# FIDELITY TOWERS

## SITE NAME: FALCON FIRE STATION No. 2

### SITE NO: CO2019

A-1

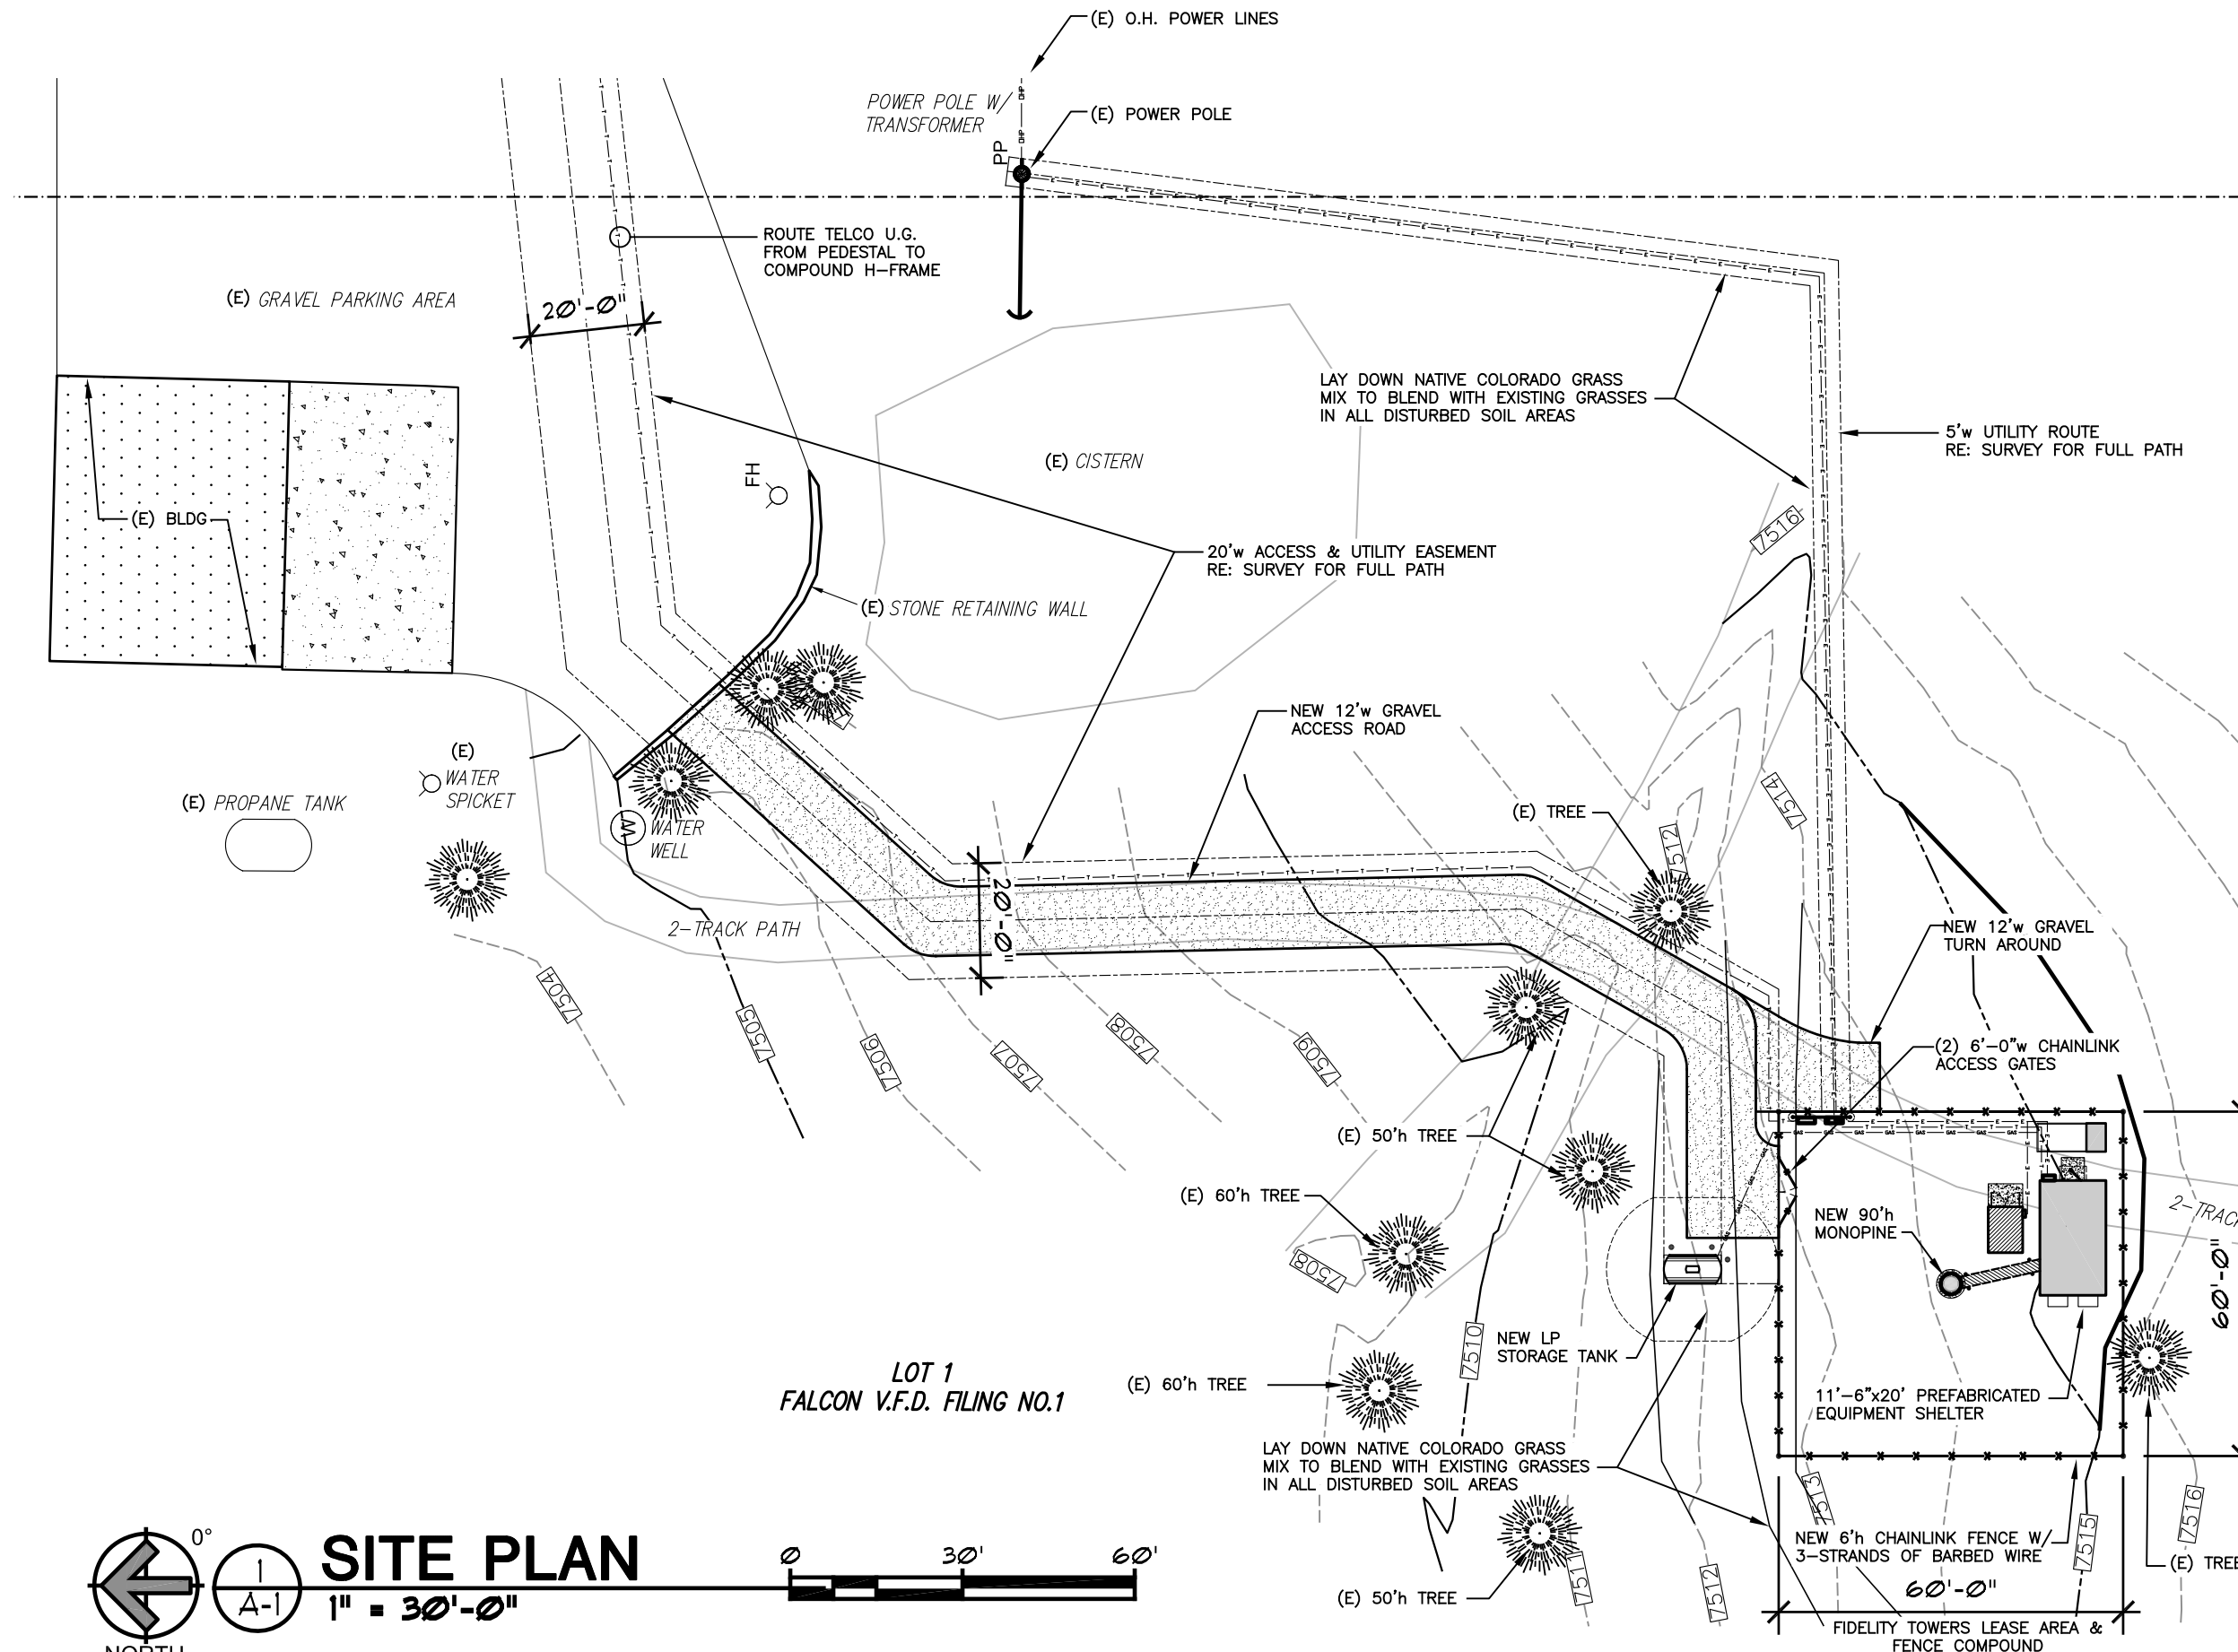
Previous redline:

please add the following to  
the site plan:

-Existing/proposed land use  
and parcel size
